From: Clerk [REDACTED]
Sent: 28 April 2021 10:44
To: Planning.Responses <Planning.Responses@arun.gov.uk>
Subject: RE: Planning Consultation on: BN/38/21/PL

Application No: BN/38/21/PL
Registered: 26th March 2021
Site Address: Land At Angels Nursery Yapton Road Barnham PO22 0AY
Grid Reference: 496255 104047
Description of Works: Construction of feature entrance wall set back from access to approved residential development.

| Drawing Title  |    | SITE_ENTRANCE_FEATURE_WALL_LAYOUT |            |

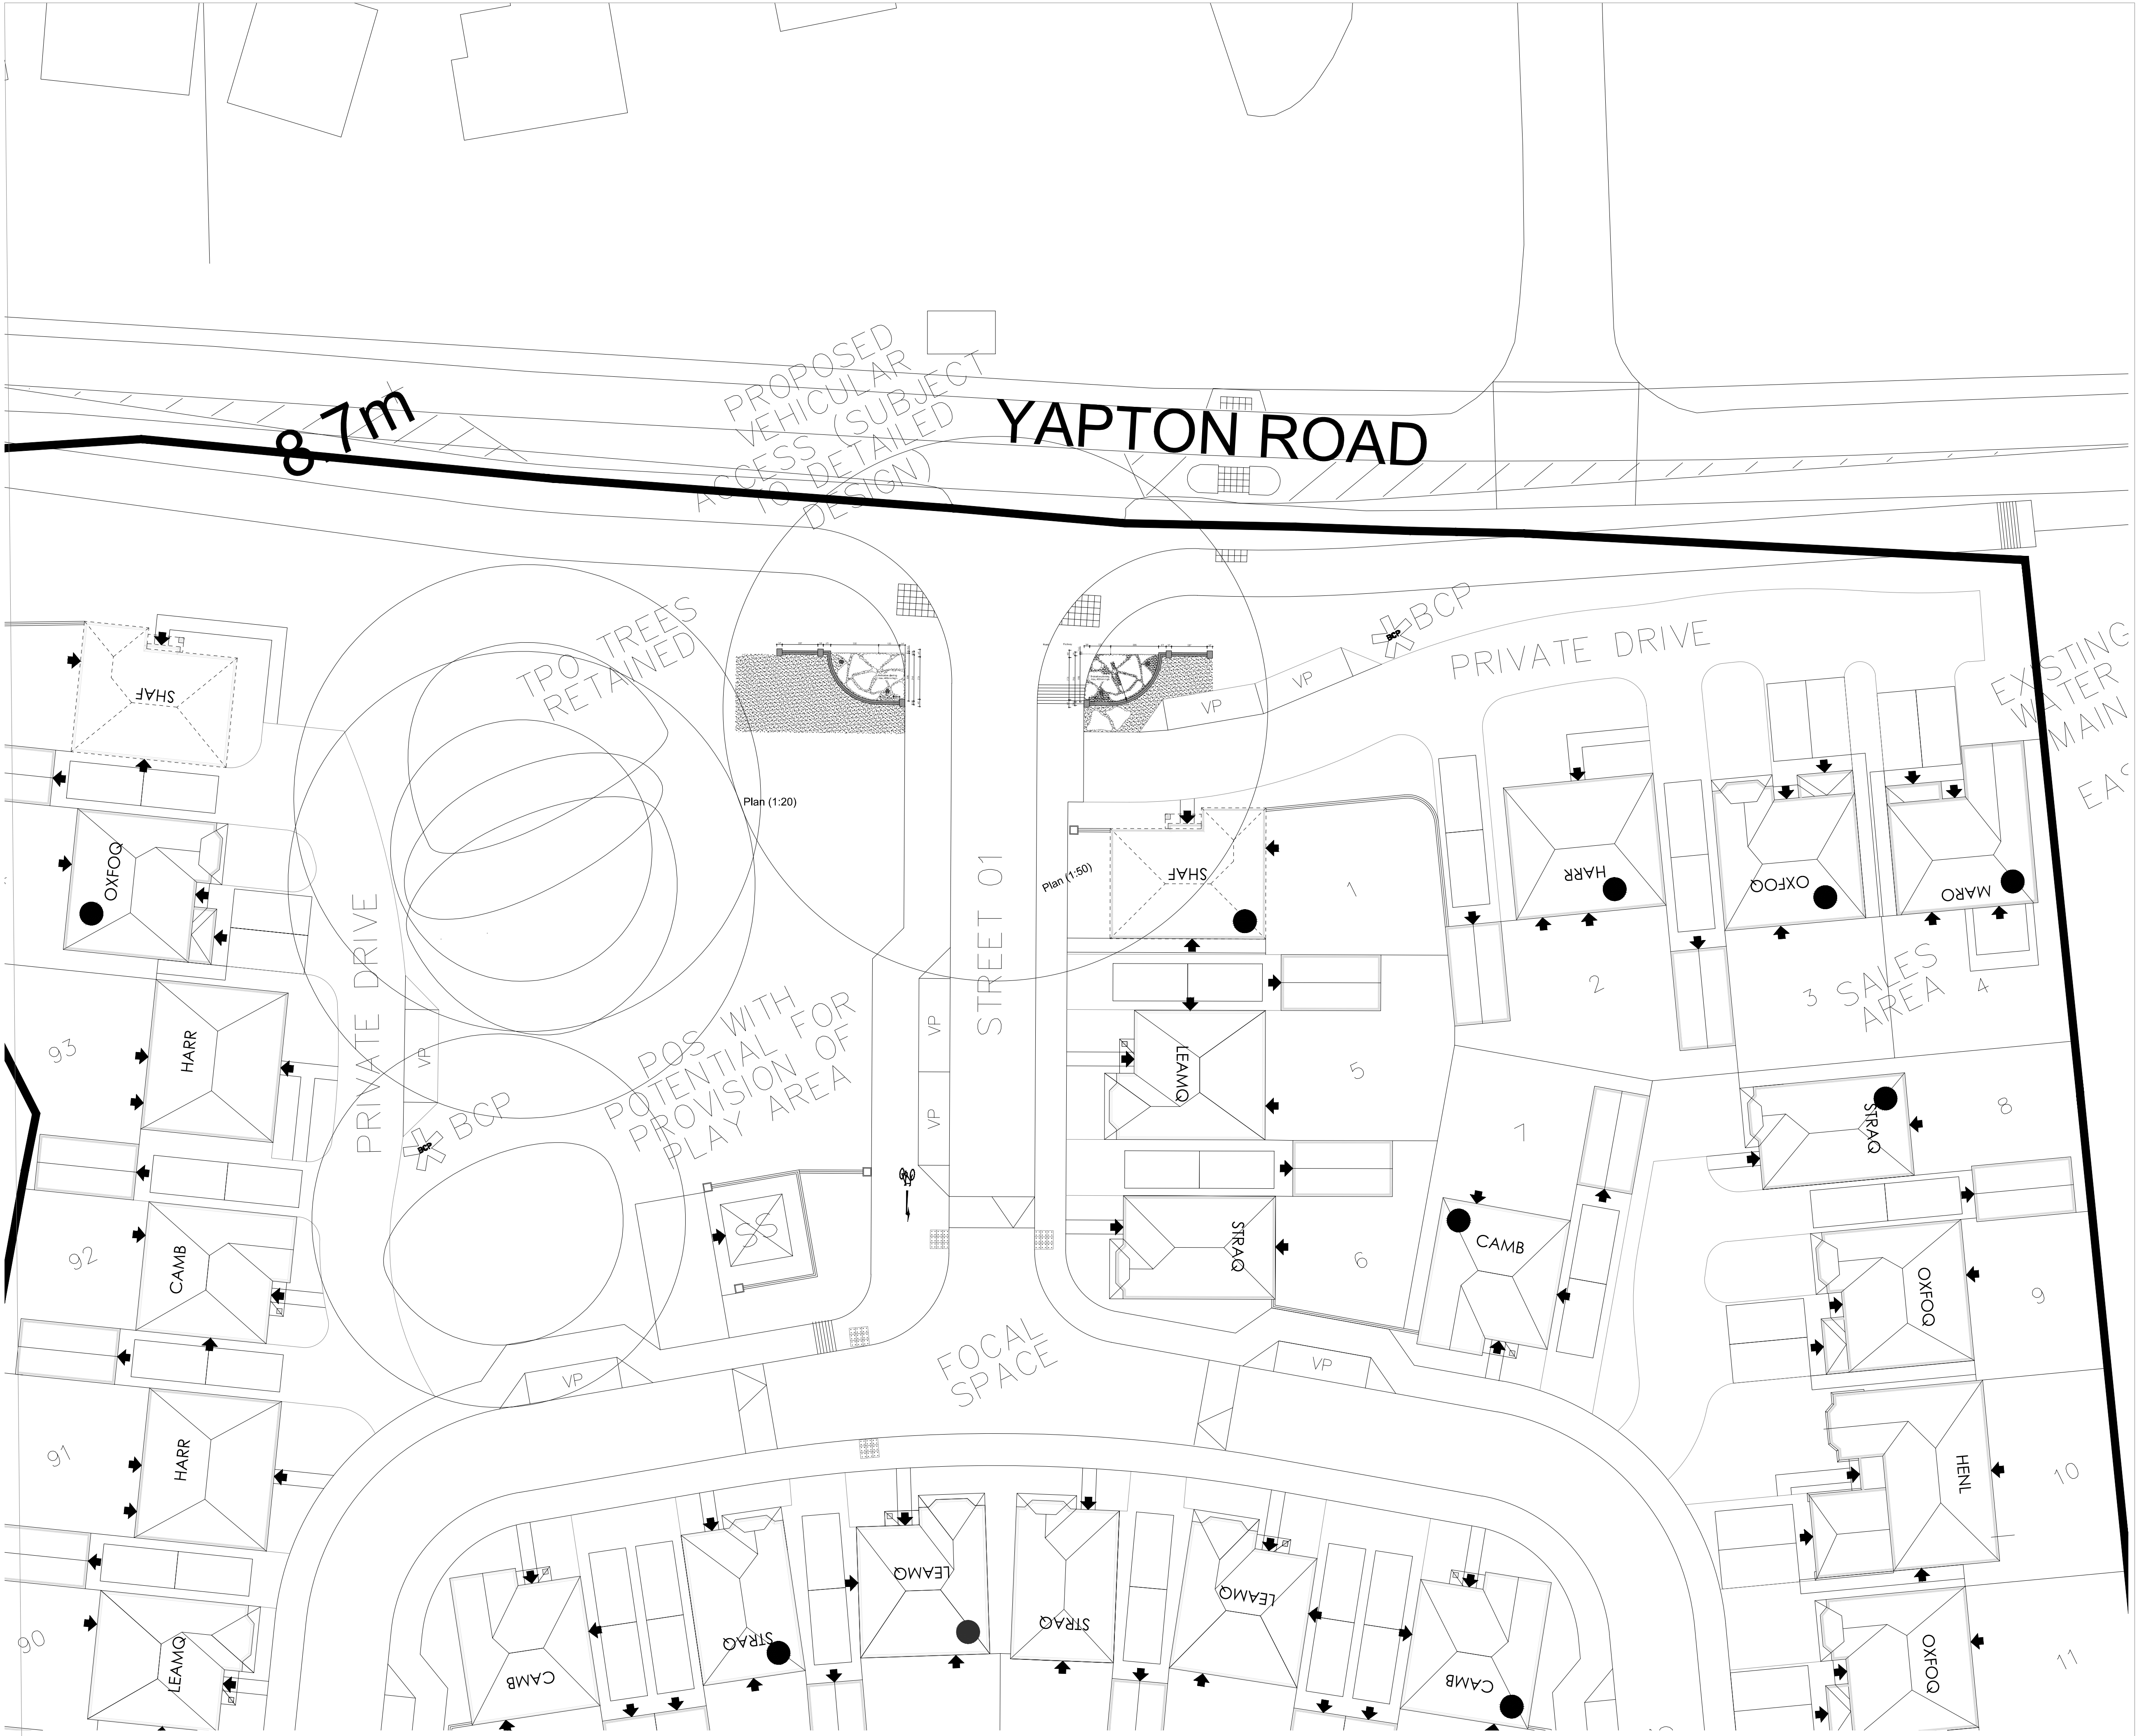
At a meeting of the Planning & Environment Committee of Barnham and Eastergate Parish Council held on 27th April the Committee resolved to submit an objection to the application as presented as the Committee believe the application should have been a 'retrospective approval' application.

The Committee would therefore request that the current application is withdrawn and the developer be asked to resubmit a new application for 'retrospective approval' and the Committee would then consider that application and respond appropriately.

As far as the Committee was concerned no plans had ever been presented to them in any applications for the development that showed the construction of a wall it was always believed that the site boundary with the Yapton Road would be landscaped with trees and hedges so they feel they need an application that explains the reasons for this change before they can formally respond.
